**Commitment Letter**

**Project Name: Bridle Bit Ranch Subdivision, Filing #1A**

**Description:** It is proposed to subdivide the ten (10) acre parcel at 12730 Bridle Bit Road into two five (5) acre parcels. This proposed development is located north of Shoup Road and east of Highway 83 in Section 10, Township 12 South, Range 66 West.

TELLE SUBDIVISION

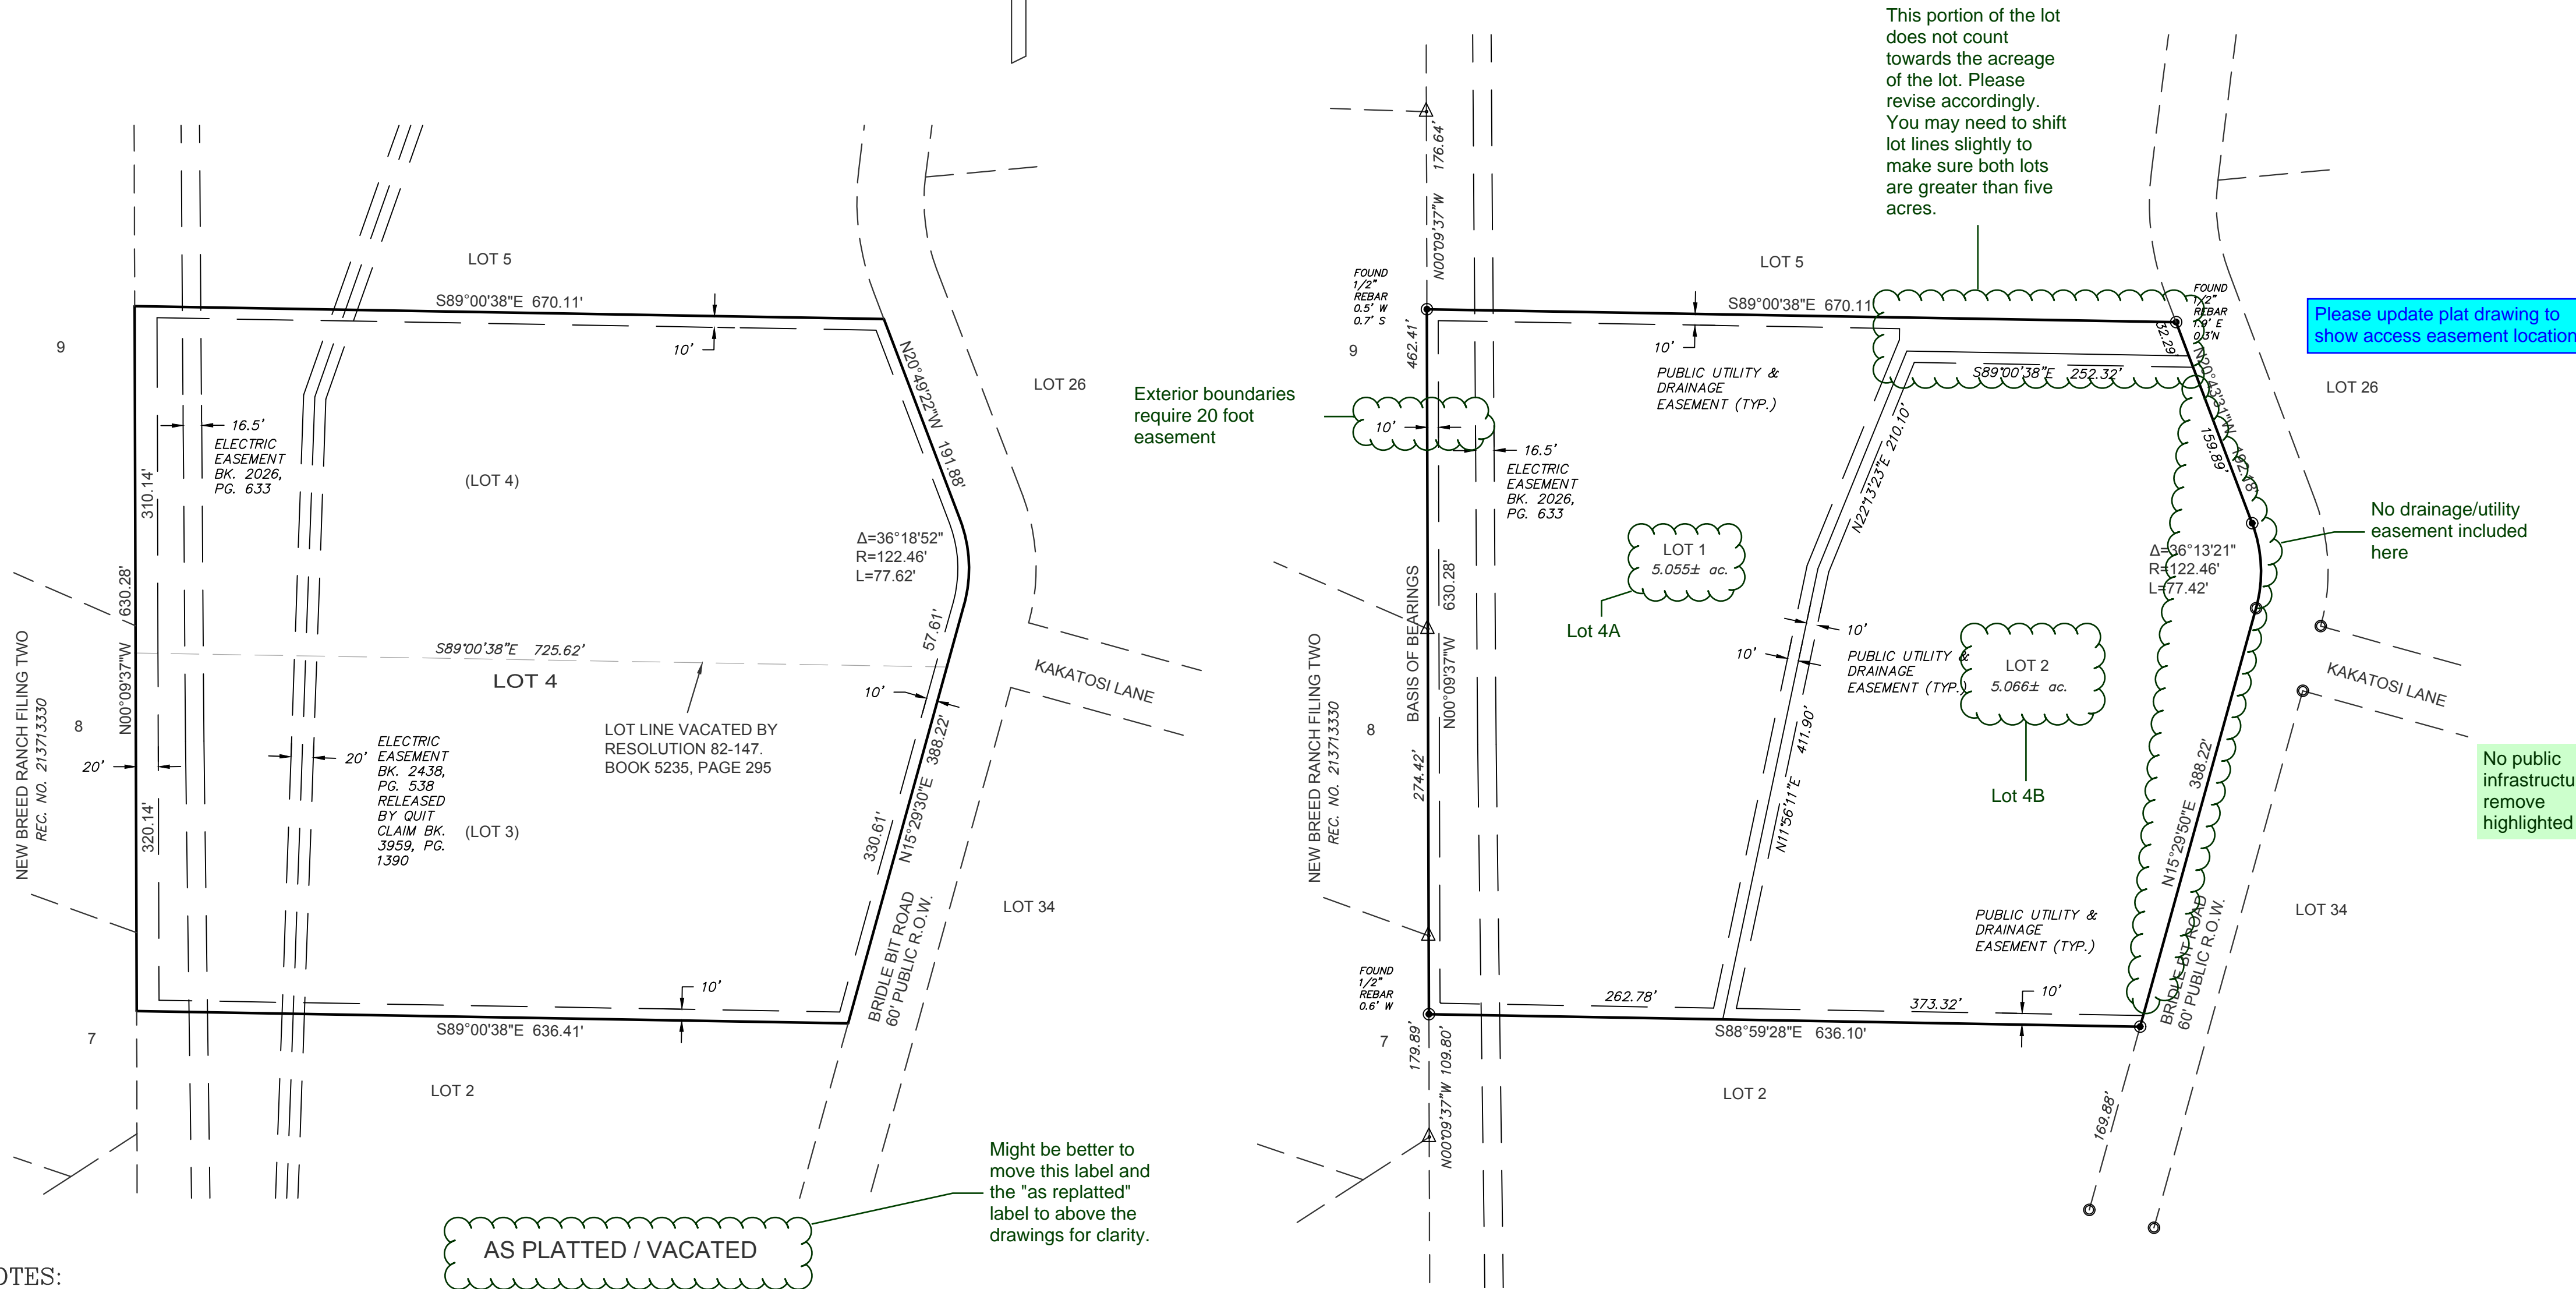
MVEA requests utility easements of ten (10) foot each side of the side lot line and the front lot line of Lot 2 along with a twenty (20) utility easement along the rear lot line of Lot 1. MVEA also requests platting of existing MVEA facilities with easement on the plat. Additional easements may be required in order to serve any new services.

MVEA has existing facilities within this parcel of land including facilities crossing the proposed lot to serve the existing lot. If there is any removal or relocation of facilities it will be at the expense of the applicant.
